Our Ref: FP/251/19/PL

**Town & Country Planning Act 1990 (as amended)
Town and Country Planning (Development Management Procedure) (England) Order 2015
Application for Planning Permission**

Development Altering of existing west access to site to allow for vehicular access for emergency & maintenance purposes only. Drop kerb formed to allow for vehicular crossover, area to include a new area of secure bin storage for the school.
fence off waiting area separating it from public access & existing vehicular entrance areas.

Location Bishop Tufnell C Of E Junior And Infant School Pennyfields Felpham

Drawing: EXISTING & PROPOSED PLANS

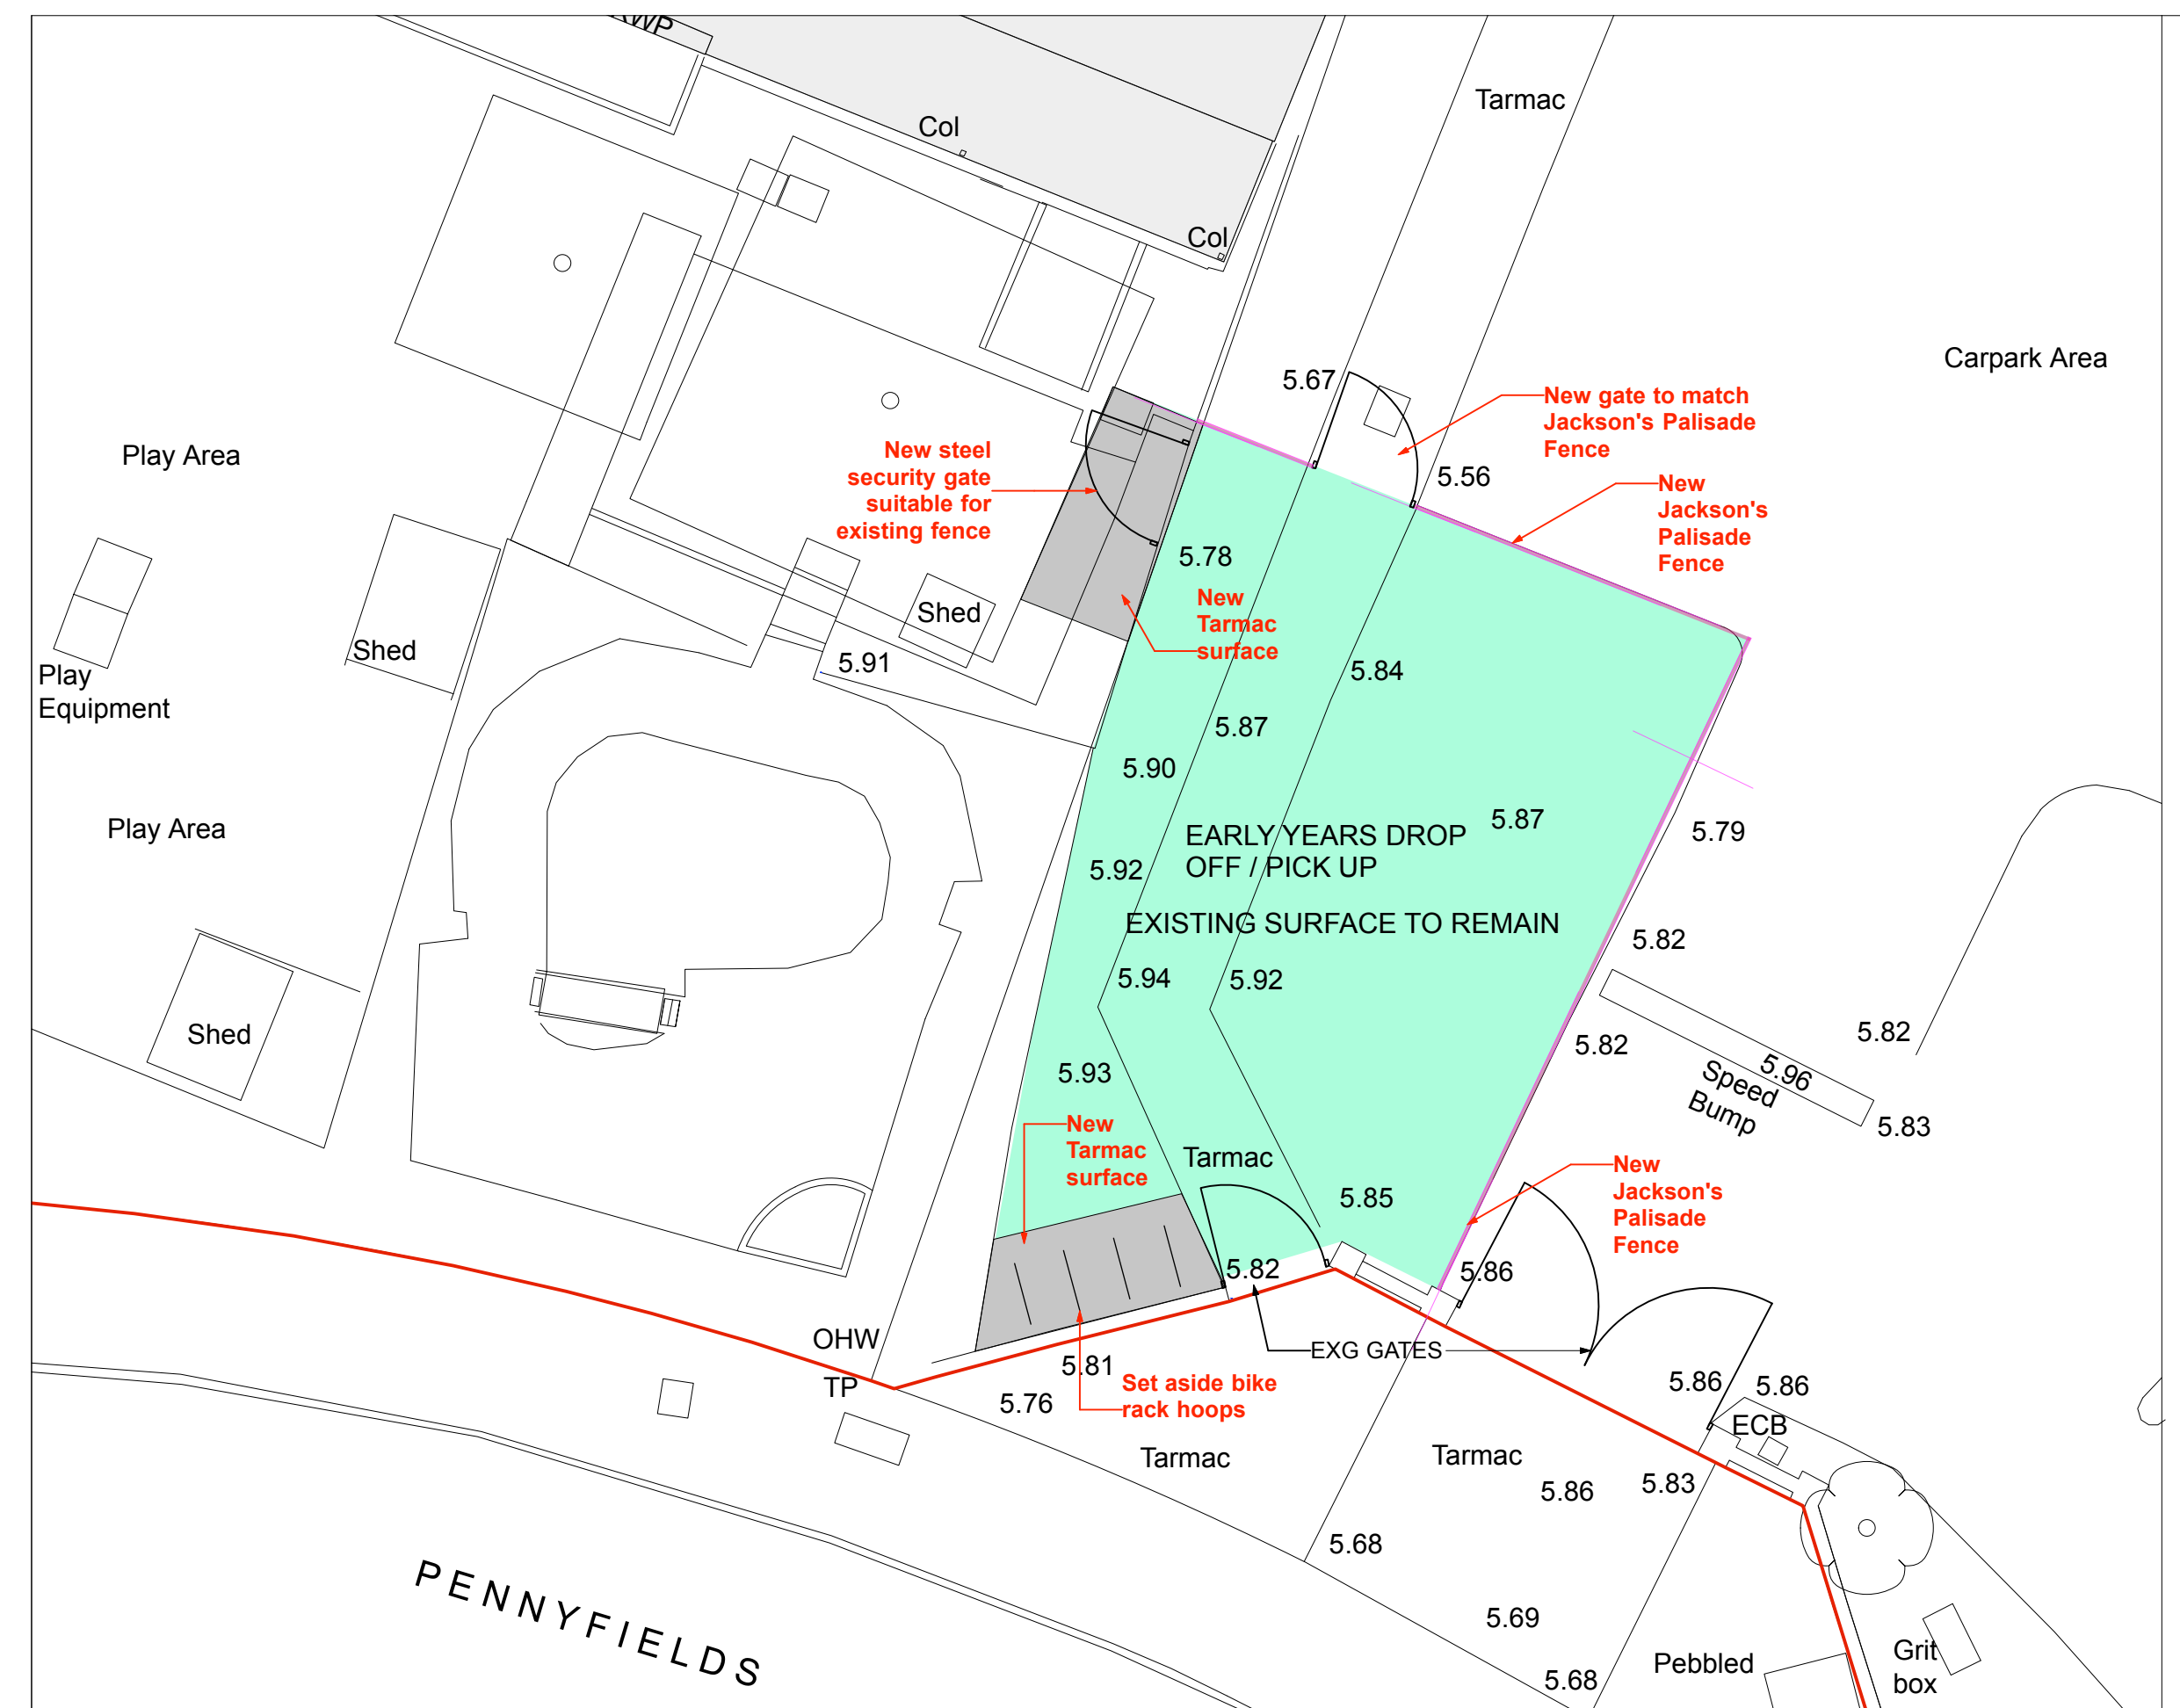
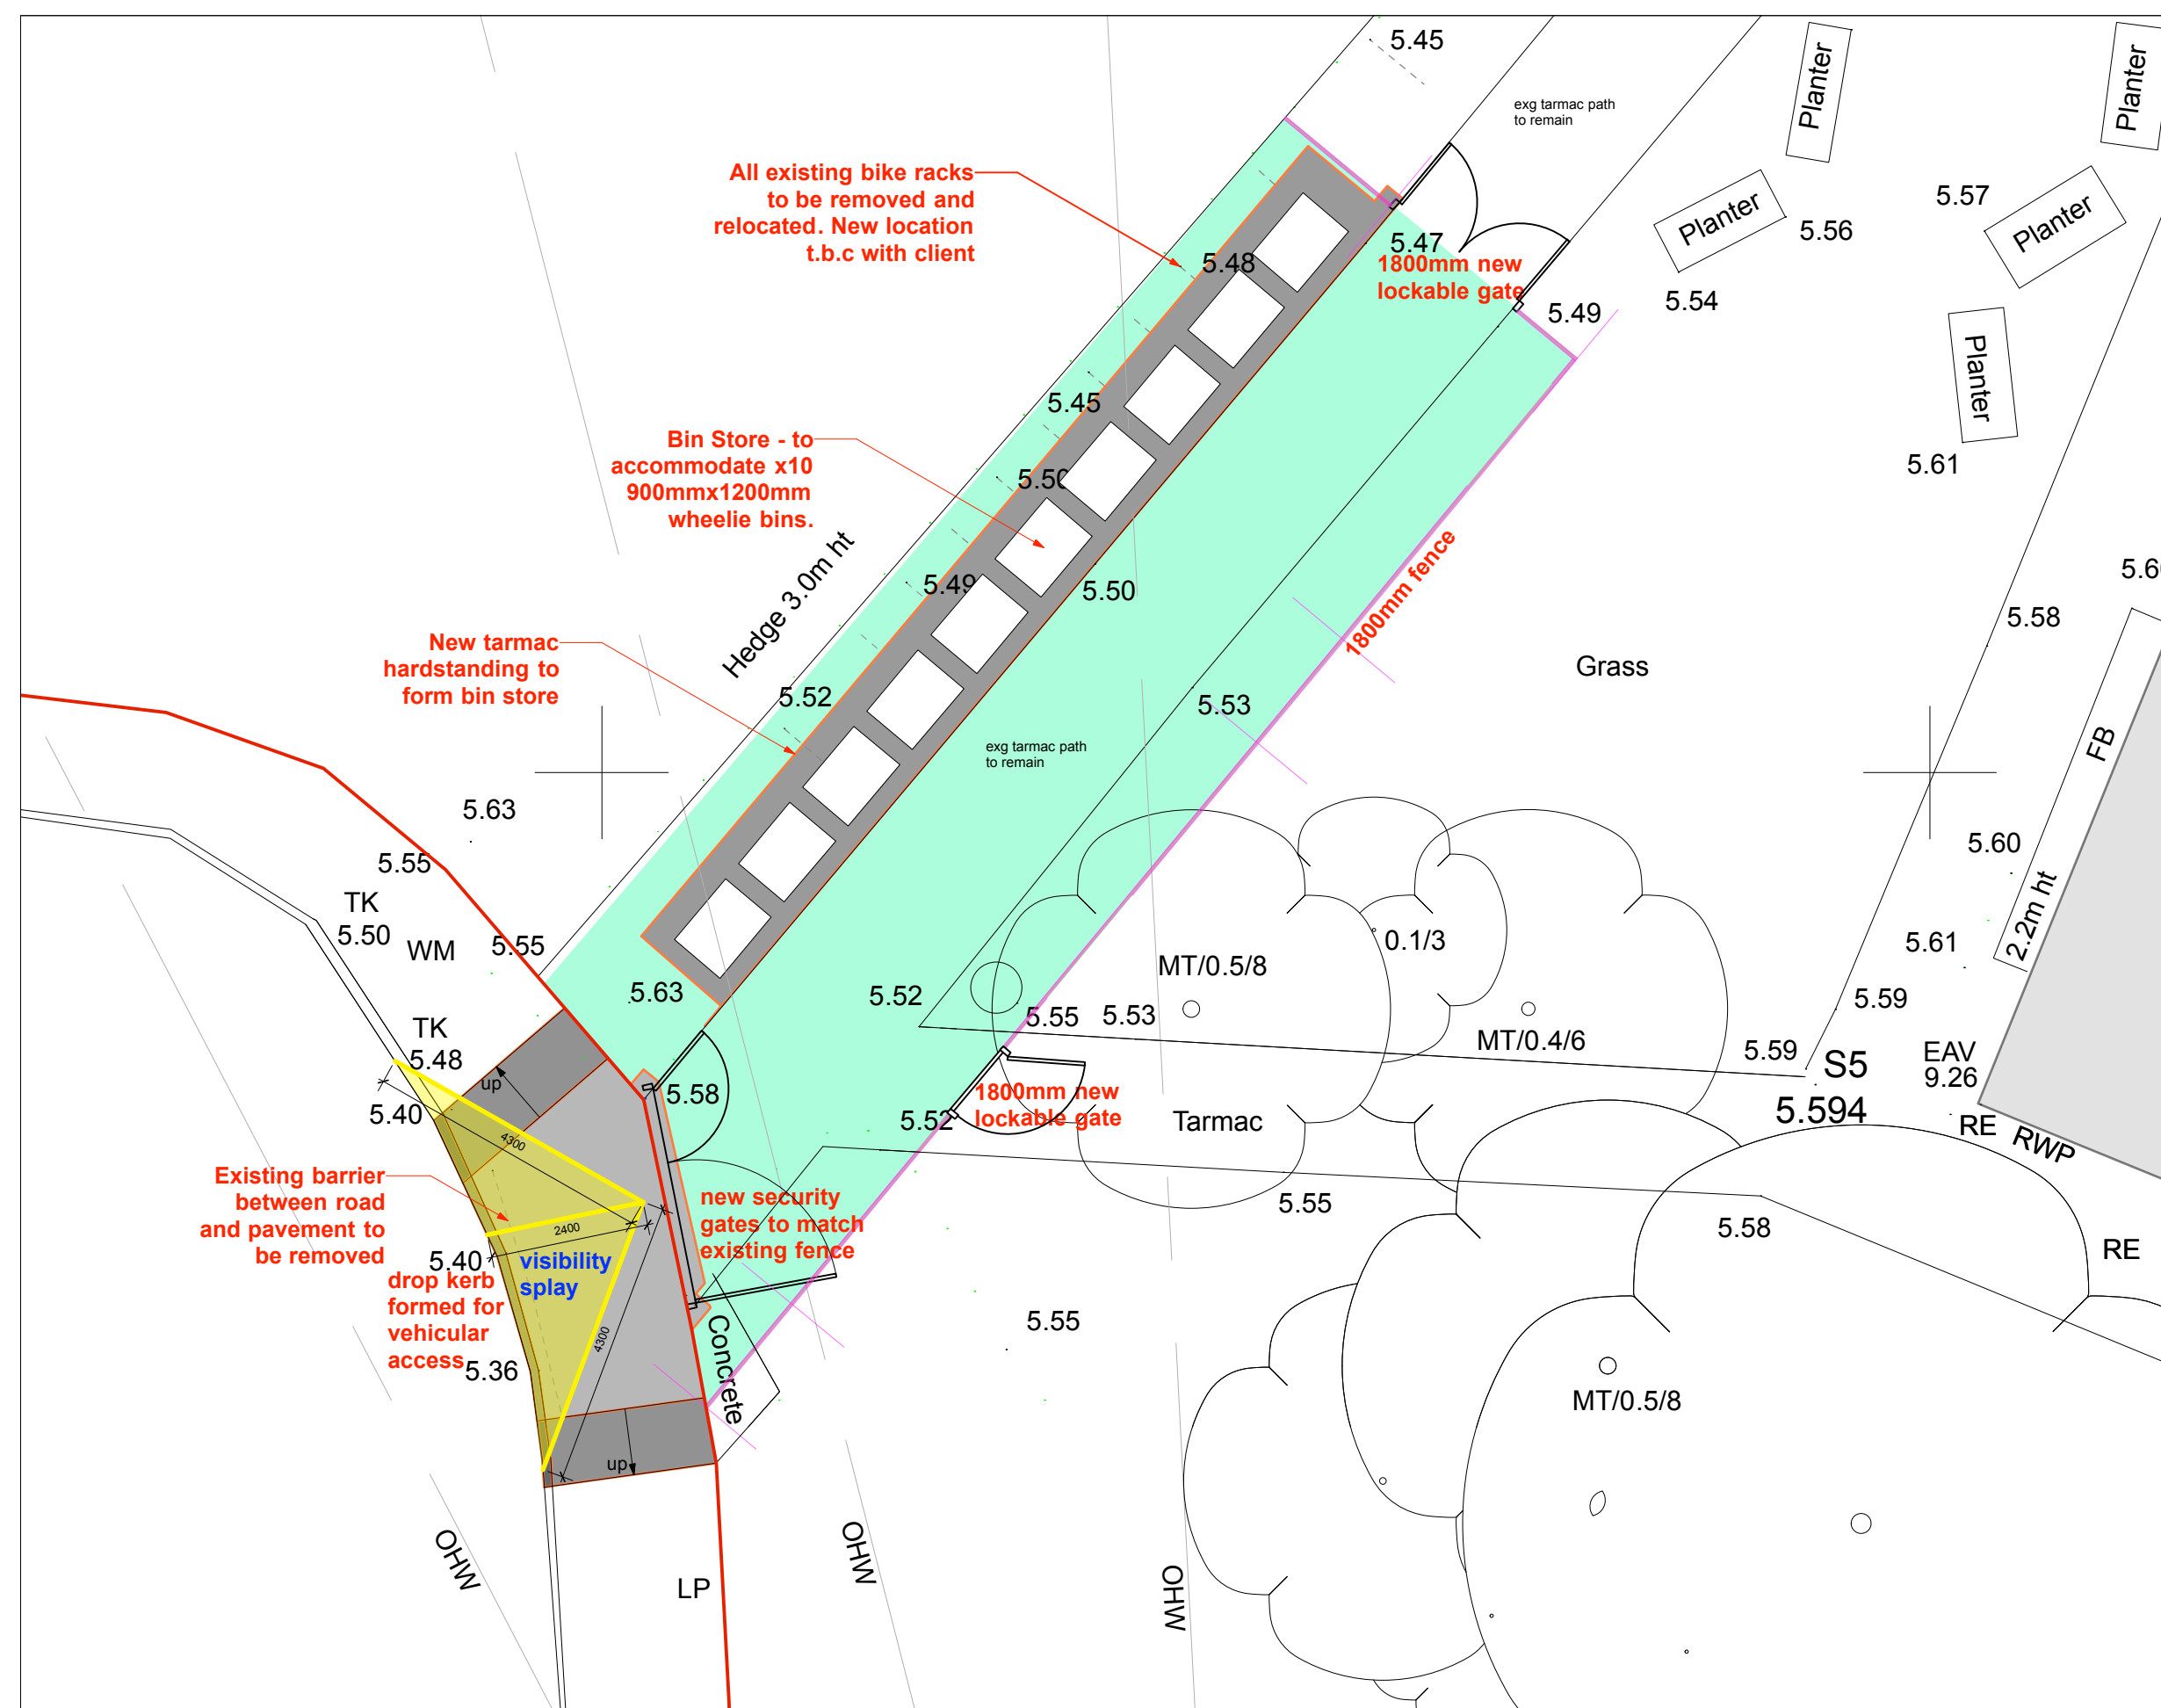
West Sussex County Council require that a visibility splay is provided. A splay is formed for a 30 mph speed limit road by measuring from a point 2.4m back from the kerb edge in the centre of the proposed access. A line should then be drawn from either side of this point for 43 m in each direction to the nearside edge of the carriage way. The splays must intersect land

only within the control of the applicant, or within the publicly maintained highway.

The distance will increase with the speed limit of the road. If the road is 40 mph speed limit then the distance should be 120 m either side. For speeds above this please contact West Sussex County Council Highways for advice on what would be acceptable.
